ATLASSIAN CENTRAL DEVELOPMENT

SSD-10405 RESPONSE TO SUBMISSIONS & SUPPLEMENTARY DESIGN REPORT

30/06/21

Figure 2 Crown Axonometric showing the proposed changes to the rooftop balustrades.

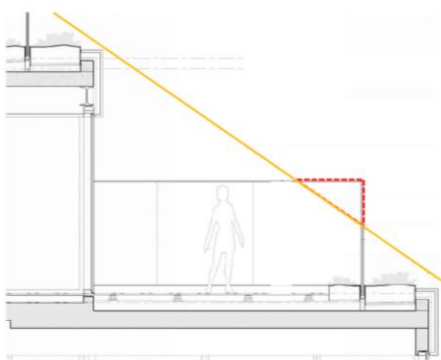
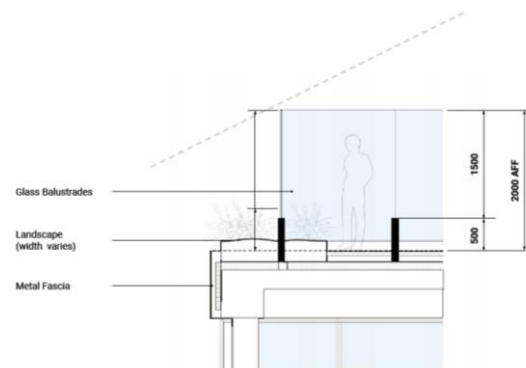
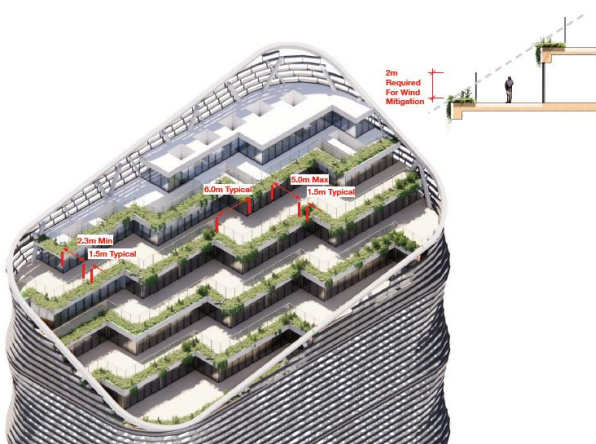
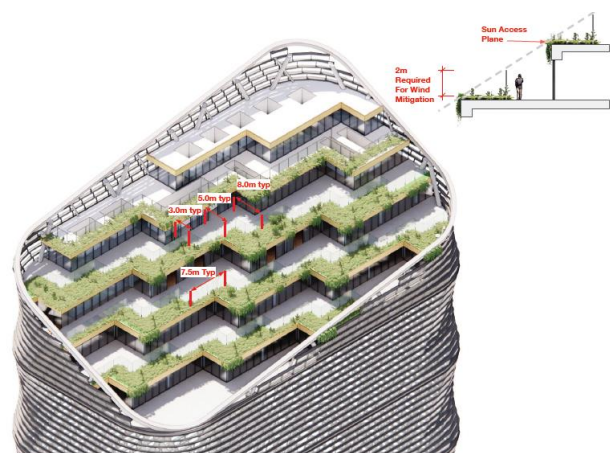
This is avoidable and can be fixed. The development overshadows Prince Alfred Park by way of high glass balustrading to the roof terraces. The sun access plane forms part of the Central Sydney Planning Strategy sets the limit for overshadowing over the park.

The City strongly objects to this overshadowing beyond the limit - it breaches the sun access plane to the park. This has previously been brought to the applicant’s attention and is easily remedied. The section below shows the extent of balustrade which causes the impact. Reducing the extent of private terrace footprint and height of glazing (and its structural support) will remove the impact completely and comply with the limit of allowable shadow. The Department should avoid a precedent for future development at Central Station and enforce compliance with the sun access plane.

The glass balustrades have now been set back from edge of terraces and do not encroach sun access plane.

The setback distances varies throughout from one to three metres to ensure the sun access plane is not intersected.

Balustrades and landscape design and details will be further developed in later stages of design.

Figure 13 Tower Soffit Lowering

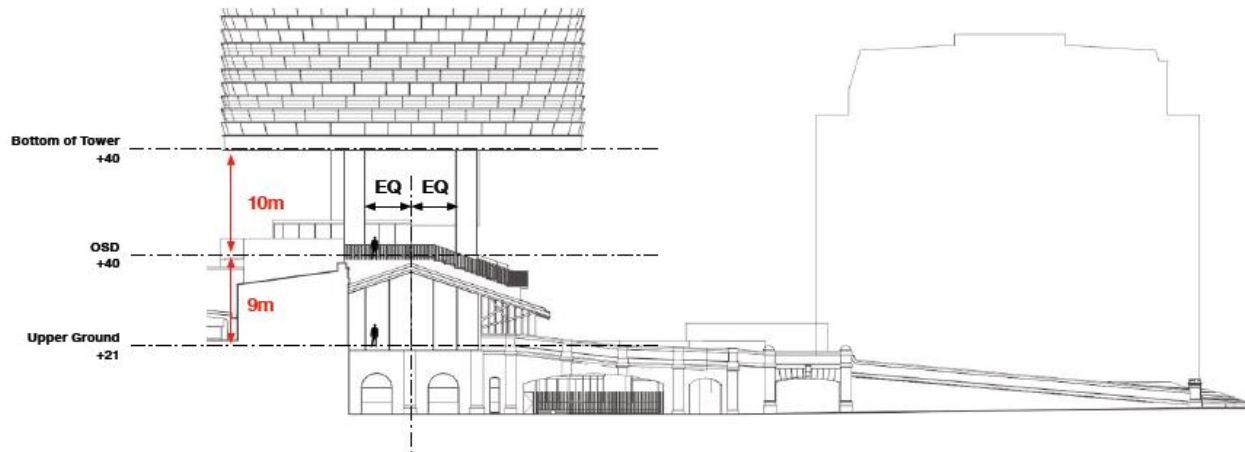
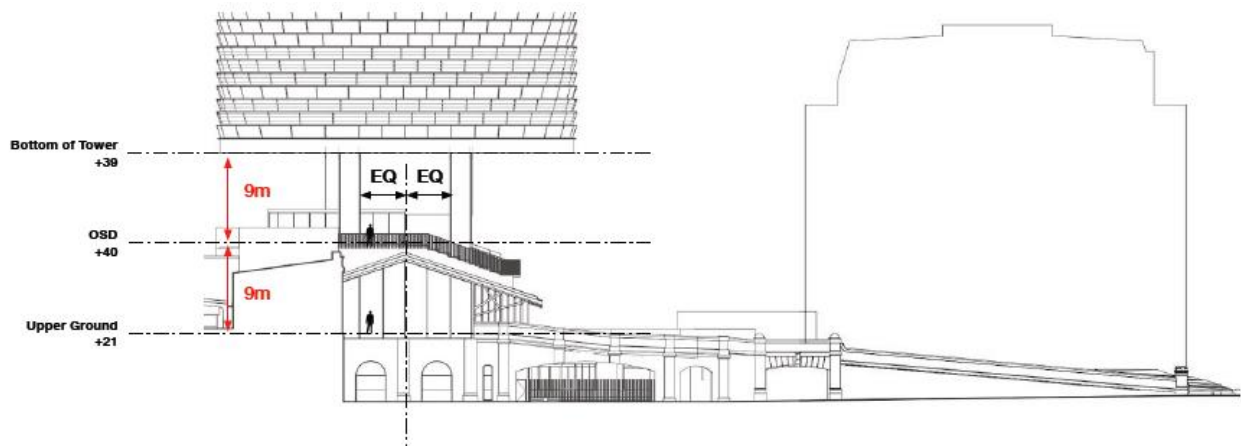
External Stair	
Requires further design development to be reviewed by the DIP.	Refer 1.4.1 GANSW Comment
Tower Soffit	
Proposed approach is supported in principal, recommend that detailed design is reviewed by the DIP.	Refer 1.4.2 GANSW Comment
Stepped Floorplates	
The change to the typical floorplate arrangement that reduces the extent of the ‘stepped floorplates’ in the south-western section of the plan was not raised by the proponent at the DIP session. GANSW have concerns with the impacts of this change on design excellence, noting dot point #6 from the Competition Jury Report: The Jury strongly support the spatial condition of inverted timber framed stepped back floorplates and landscaping elements within the facade, and this should be maintained.’	Refer 1.4.4 GANSW Comment
This change requires further explanation and justification from the proponent including drawings that indicate its design impacts both external and internal, this should be presented to the DIP pre-RtS.	Refer 1.4.3 GANSW Comment
